Construction of a single storey office extension to the rear of the property, including the removal of the existing store room. Works will also include the replacement of the existing shop front and dwarf walls with fully glazed aluminium windows and doors.
Retail area to be used as showroom.

1 Avisford Terrace, Dillons Newsagents Rose Green Road Aldwick

Thank you for your internet representation made on 30th April 2020 which has been recorded as **'an objection'** with the comments as follows:

NOTES:	
PROPOSED EXTENSION & NEW SHOP FRONT AT 1 AVISFORD TERRACE	
PROPOSED FLOOR PLAN & BOUNDARIES	
Britannia Windows 1 Avisford Terrace Rose Green Road Bognor Regis PO21 3HB	
Contract No:	
Drawn by: PDS	
Surveyed by: PDS	
Scale: 1:75 @A3	Date: 15/04/2020
Drawing No: 07.A

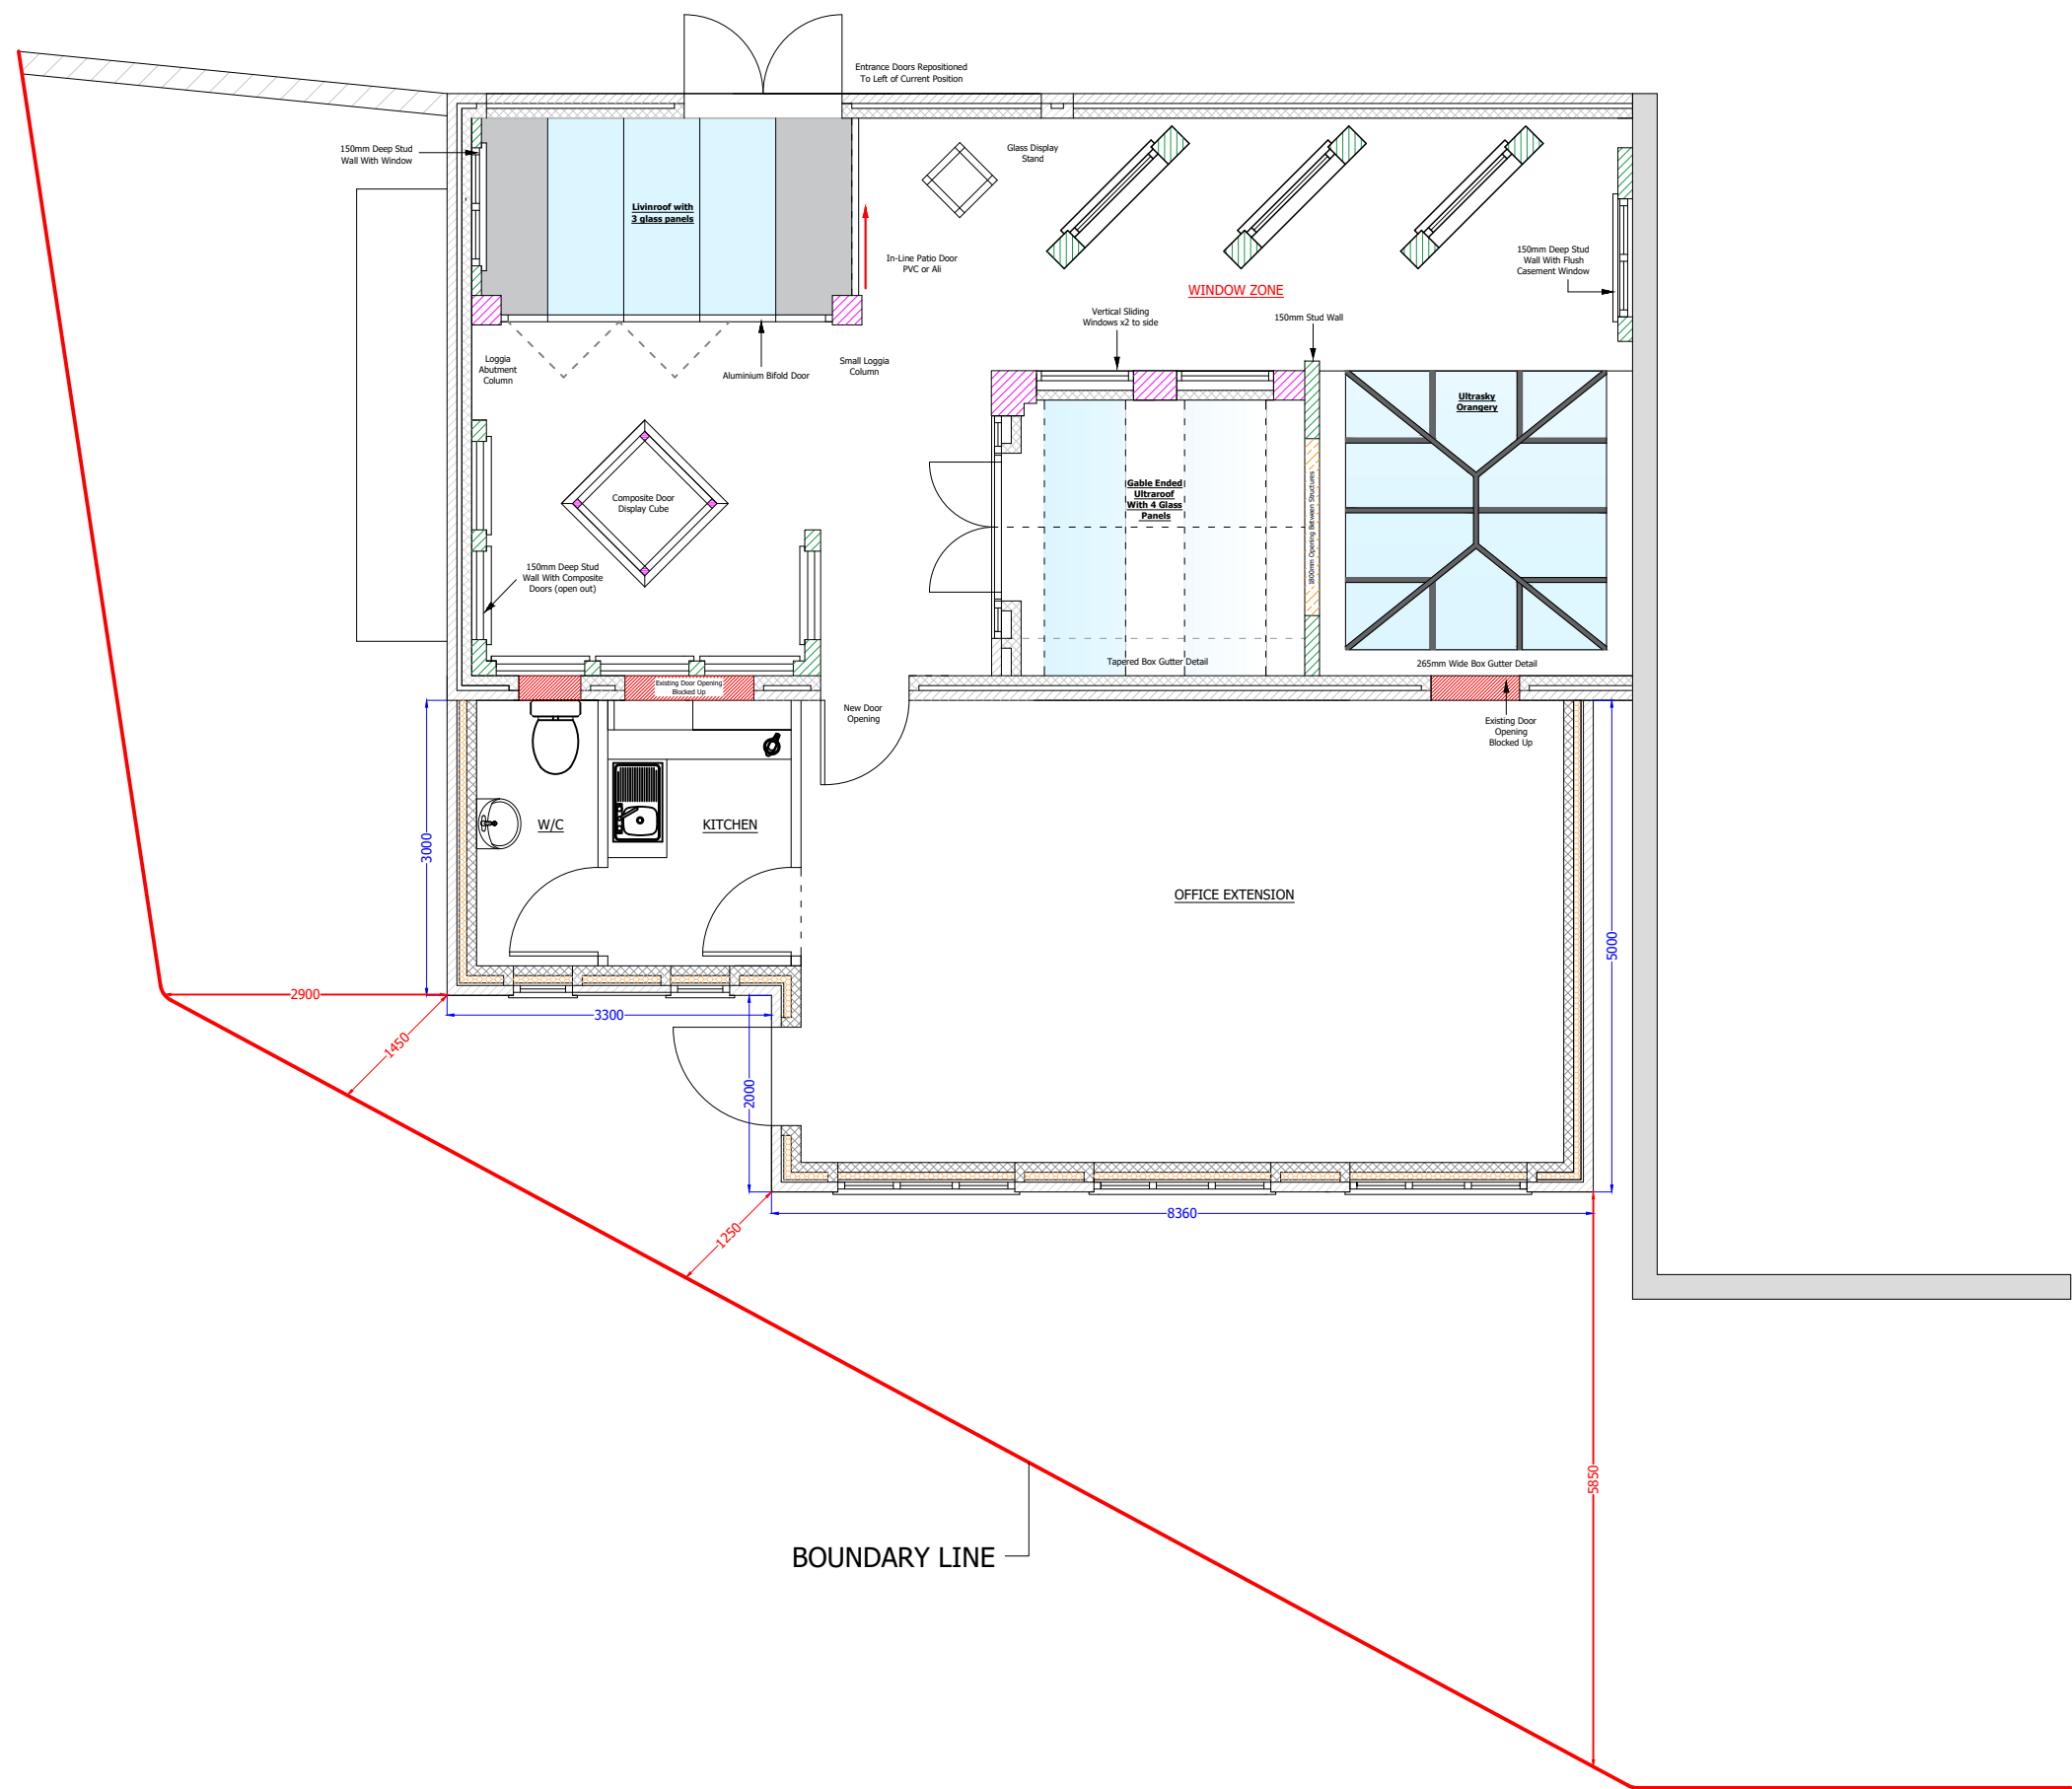
I have a strong objection to the detail of the entrance doors which open onto the public footway beside the highway. The doors should be made to open inwards so that on exiting (for example) a visitor leaving didnot open the doors into the path of a disabled person. This area is very full of elderly people as a high proportion of residents locally are retired. It is very likley that in this location wiht food and vegetable shops , bakery and PO there will be such people with poorer than average eye-sight and possibly some quite blind. Please ensure doors are designed to open inwards.
THIS IS A MATTER OF DETAIL BUT NONE THE LESS IT IS SIGNIFICANT TOUSERS OF THIS AREA FOR THEIR ESSENTIAL SHOPPING
